From: Graeme Thorpe
Sent: 04 January 2012 08:57
To: Jane Tucker
Subject: FW: COMMENTS ON PLANNING APPLICATION 3/2011/0971

Planning Application 3/2011/0971 Cobden Mill Sabden

Rev: B - Additional Dimension Added / SP		28.11.11
revision:		date:
client:	project:	drawing:
	Cobden Mill, Seabed	Apartment Plans
project no:	drawing no:	revision: drawn: checked: date: scale @ A1
6131	P06	B SP PC 15.11.11 1:100

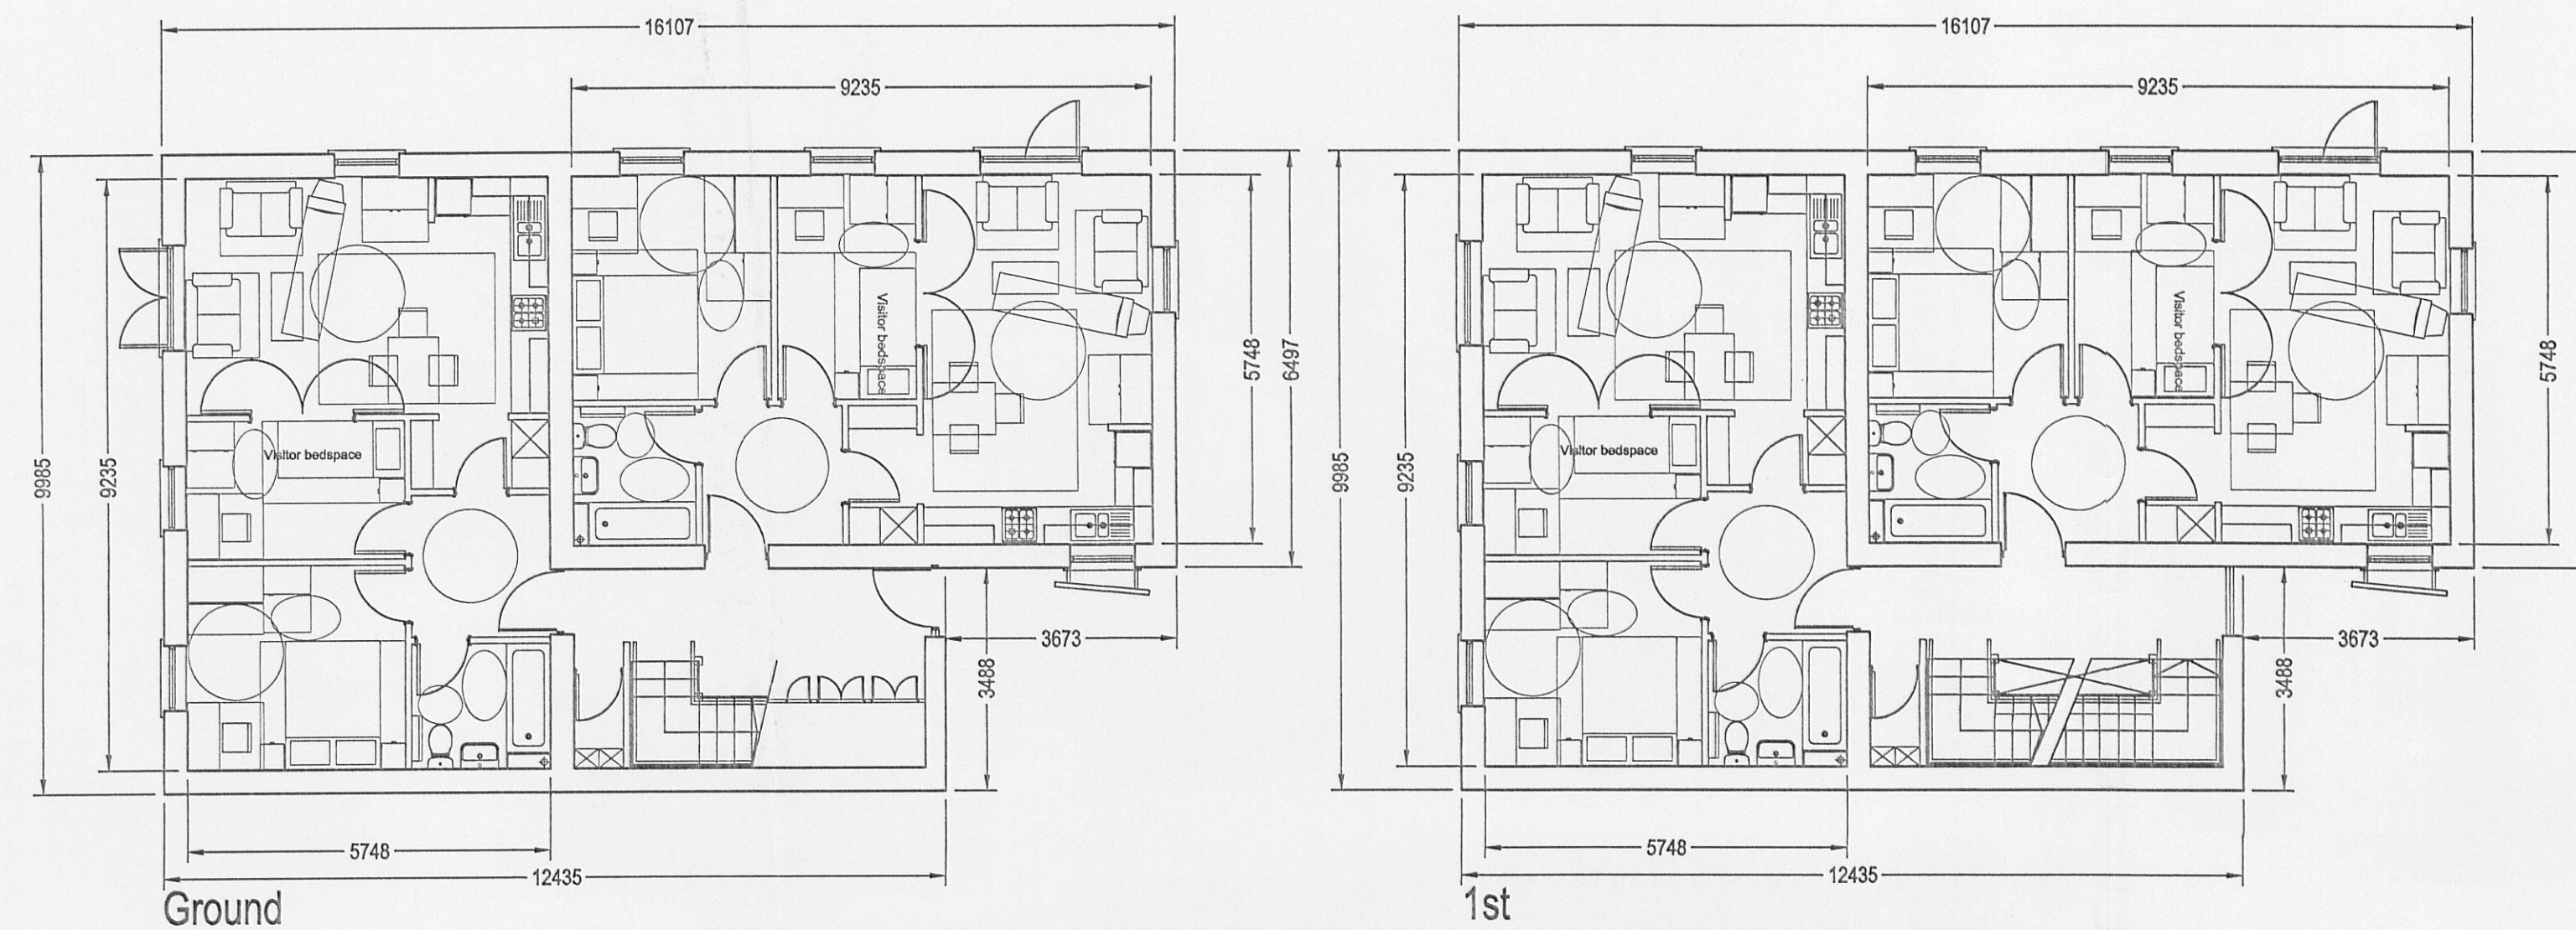
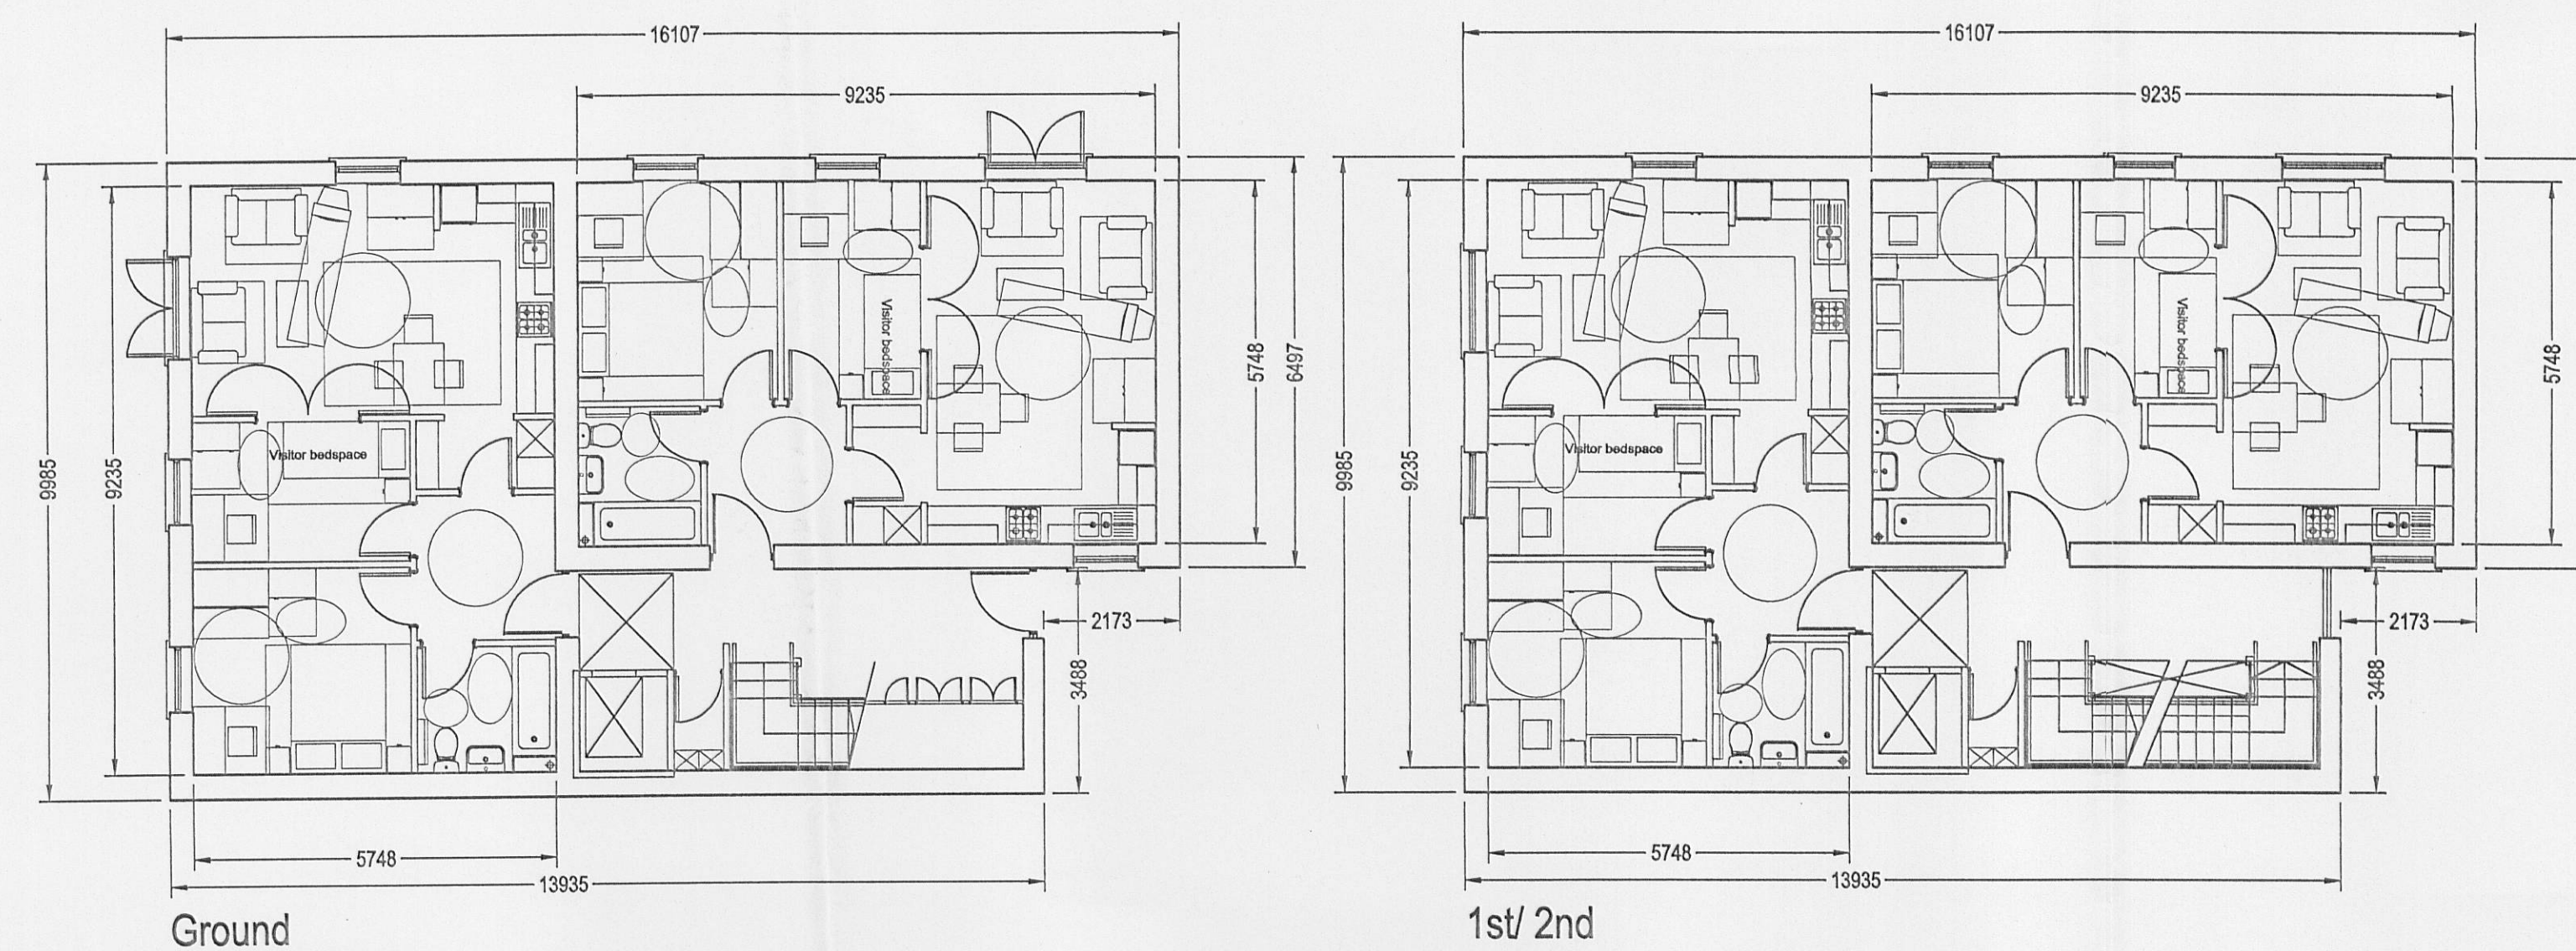
1. **The FLAT roof of the 6 apartment block** is out of character on this site, within this area which has stone built, pitched roof properties & in an AONB & will be visually intrusive. The parish council recommend a pitched roof to improve visual impact.
